From: [Haley Mercer](#)
To: [Jeremiah Cromie](#)
Subject: RE: LPF-22-00007 Forest Ridge Ph. 5 Final Plat Notice - Request for Review/Comments
Date: Tuesday, September 13, 2022 3:08:07 PM

Subject: LPF-22-00007 Forest Ridge Ph. 5 Final Plat Notice - Request for Review/Comments

CDS has received a final plat submittal for Forest Ridge Ph. 5 (LPF-22-00007). This was given preliminary approval on 12/28/2010. Let me know if there is documentation you need to review that you are unable to find. I have placed the original plat approval resolution and SEPA MDNS in the application materials for reference.

FOREST RIDGE - PHASE V PERFORMANCE BASED CLUSTER PLAT

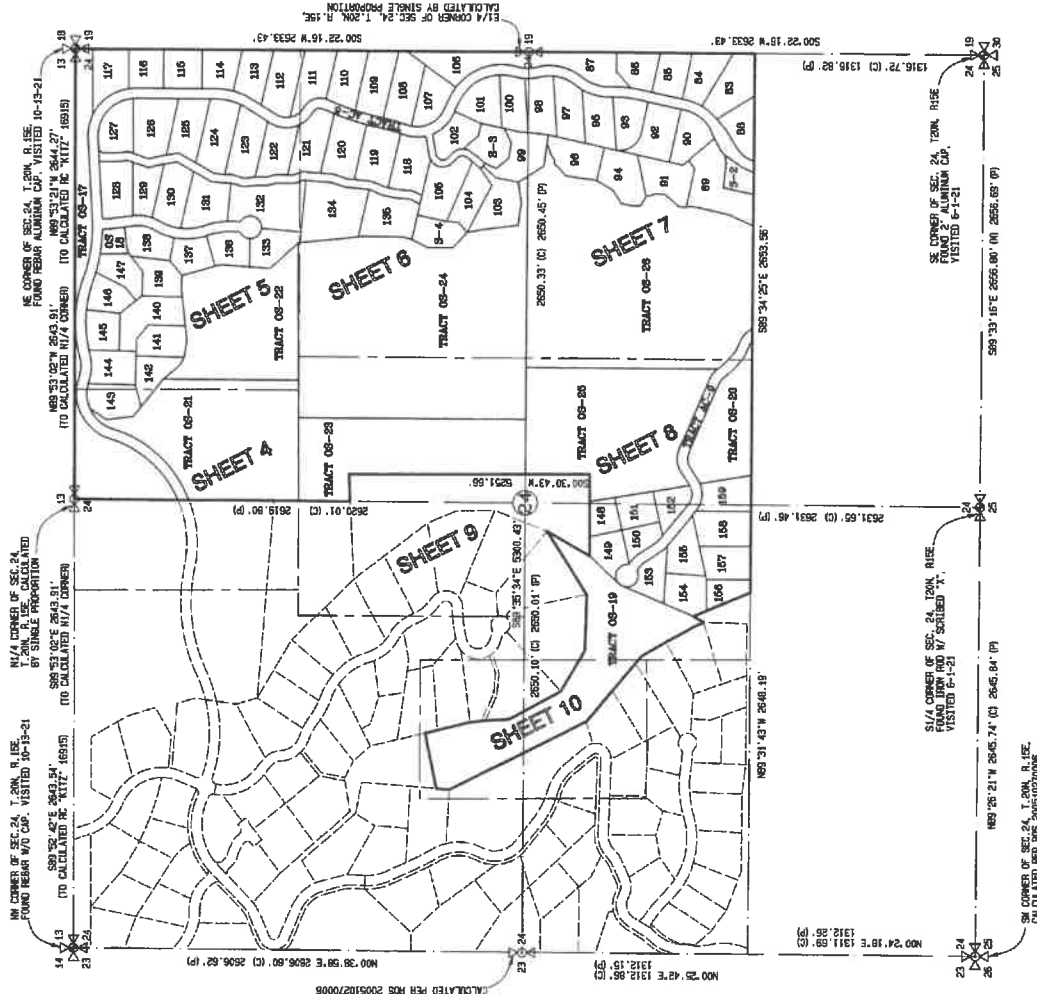
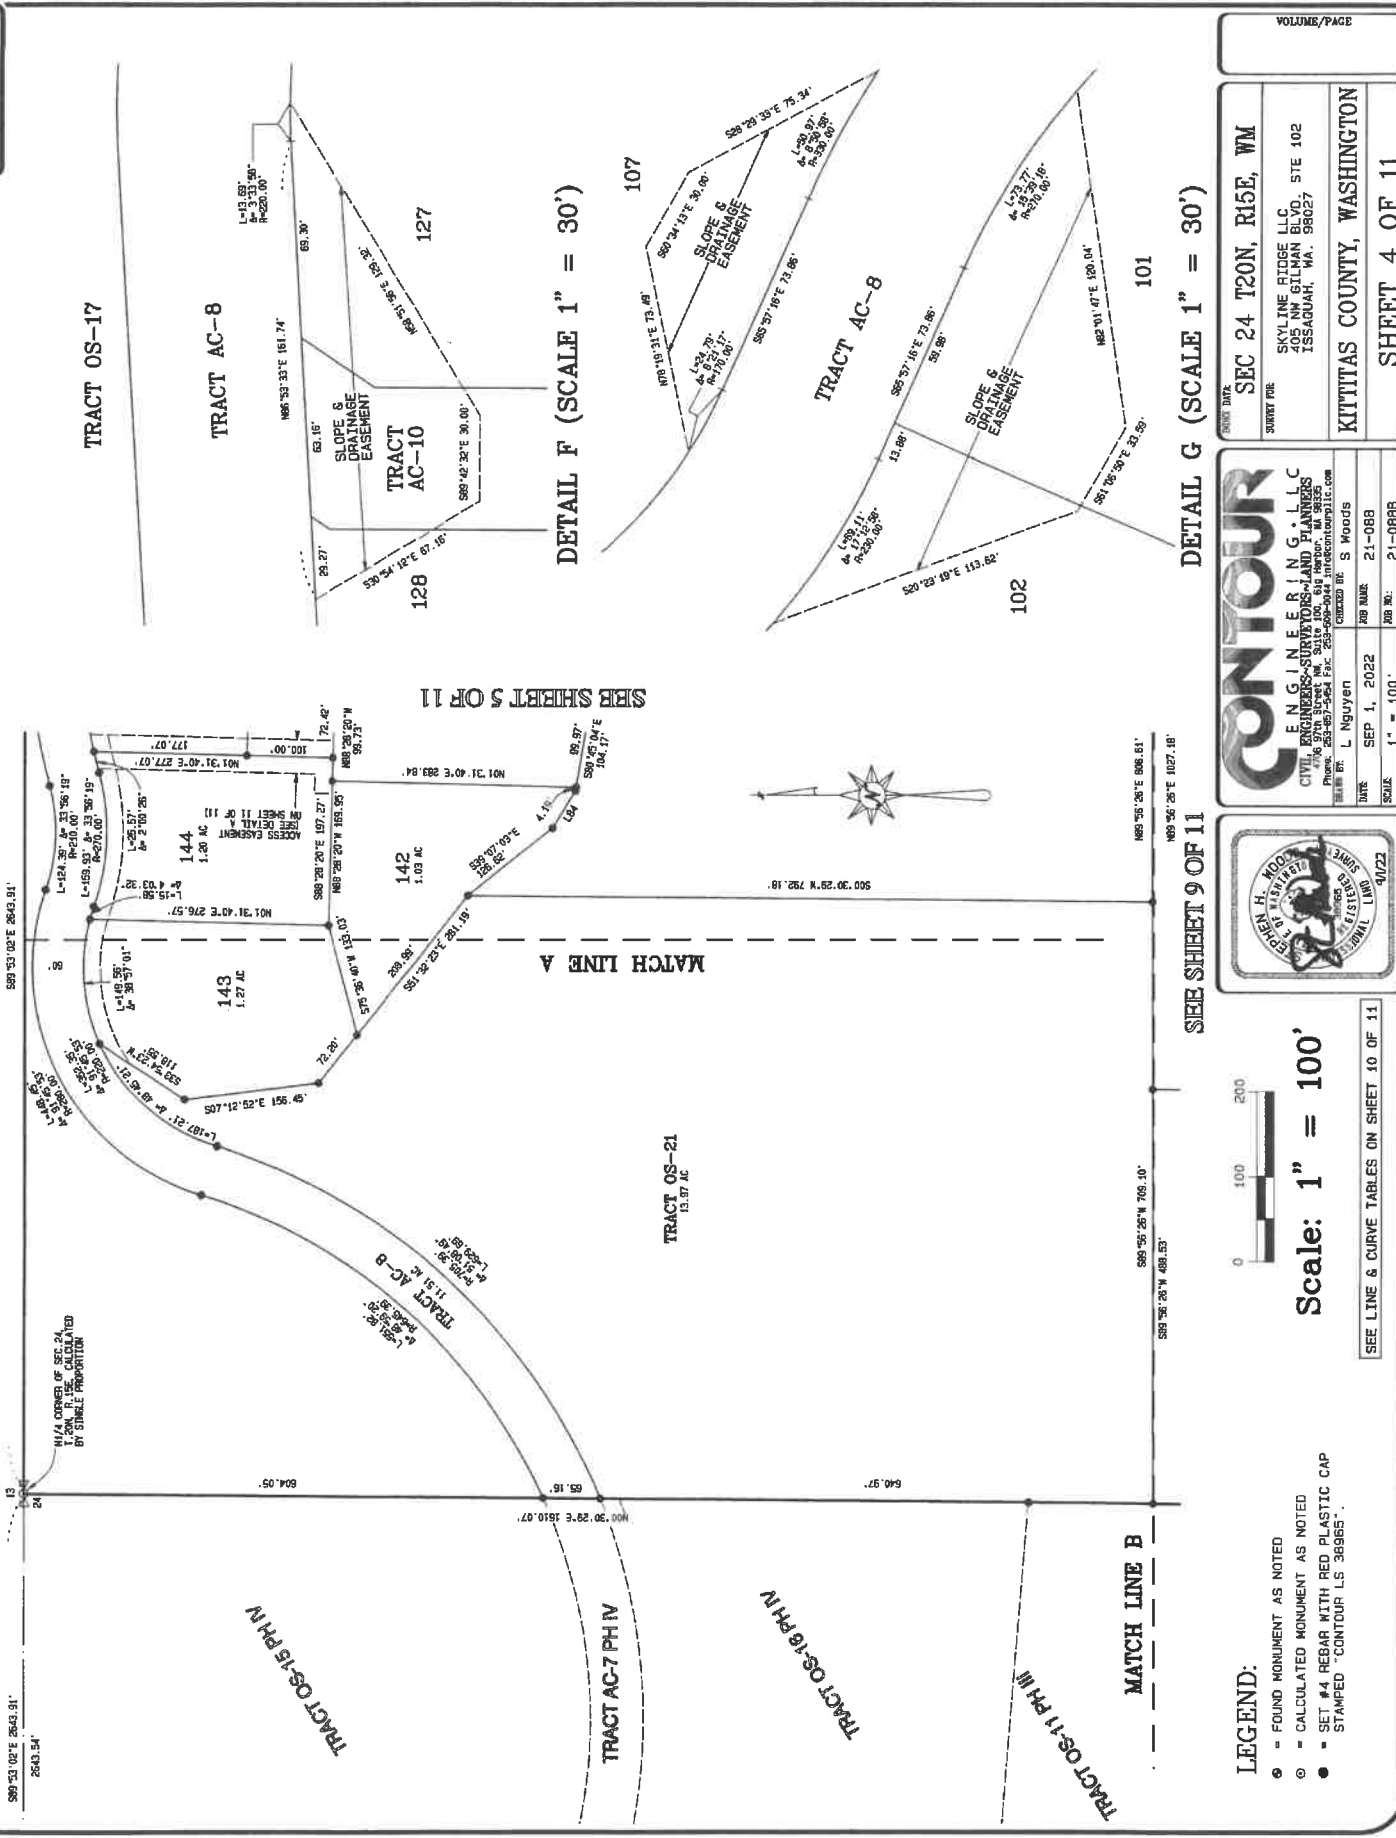
In addition to the parcels listed as existing on the plat provided. Parcels 962332, 962334, 962338 and 962153 are not included in that list.
